**From:** Trish Lyons <Trish.Lyons@hertfordshire.gov.uk>  
**Sent:** 01 February 2021 09:00  
**To:** Clare Howe  
**Subject:** Frobisher Way, Hatfield (HAT2) 6/2018/2768/OUTLINE - Highways response

A previous response was provided by HCC Highways in respect of this outline planning application in 2018, covering the following aspects: bus service, rail service, walking/cycling provision and travel plan provision.

Figure 12.2 Walking and Cycling Routes

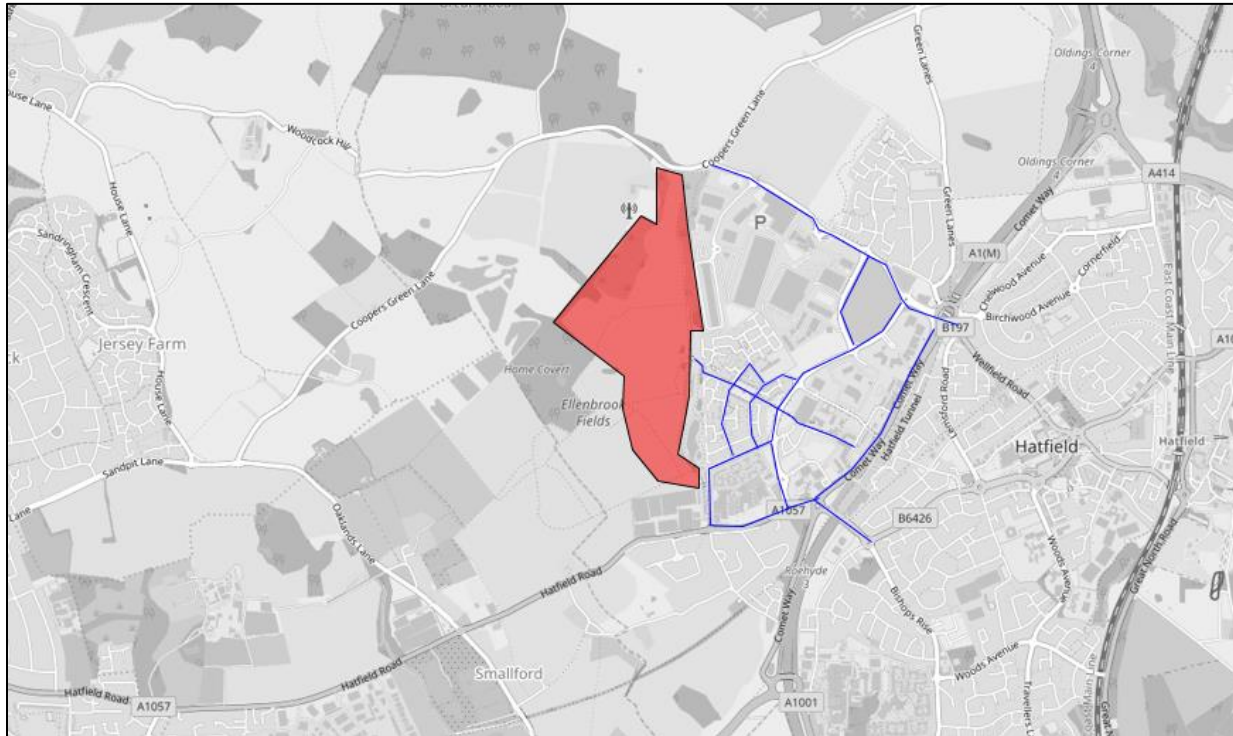
**Mitigation considered** - A shared route along Coopers Green Lane towards St Albans, judged to be unfeasible. Instead there is the intention to connect to the existing route along Albatross Way and convert the Albatross way/ A1057/ Ellenbrook Lane mini roundabout south to traffic signals presenting the roundabout as a barrier to the existing recommended on line cycle route on Ellenbrook Lane.

**HCC comments** – This approach is considered acceptable by HCC Highways and HCC is investigating alternatives to Coopers Green Lane for delivering a Hatfield to St Albans sustainable transport corridor. However, whilst it is acknowledged that the Coopers Green Lane towards St Albans is unfeasible and the focus of the development should be to consider sustainable access to the south and St Albans Way, the foot path within the development parallel to Coopers Green Lane (shown on the Masterplan in the TA Amendment) must be a segregated cycleway as per LTN 1/20 and link into the adjacent facilities along Hatfield Avenue. Pedestrians currently have gated access to the development site at this location and it should be maintained, the masterplan currently does not indicate it is.

There is also a pedestrian gated access to the site circa 200m west of the above gated access on Coopers Green Lane and this should be integrated into the development also. The removal of the Albatross Way/ A1057/ Ellenbrook Lane mini roundabout suggested by the transport consultants by way of mitigation would be delivered through the S278 process. The previous HCC Highways comments also mentions the pedestrian connection to the adjacent residential area to the east of the site (Cunningham Ave/ Dragon Rd) and the shared use path to the Parkhouse Retail Park which is adjacent to the residential area. Whilst the footpath is shown as an unlabelled line on the Residential Access Road Plan (drawing 107 Rev A) it is not shown on the Masterplan or mentioned in the text. Confirmation/ continuity of this valuable link is needed and the short section of footpath upgraded to shared use to tie in with the existing facility.

The TA and Amendment indicate that a network of high quality cycle routes will be provided throughout the site it is important when it is finalised it incorporates these accesses.
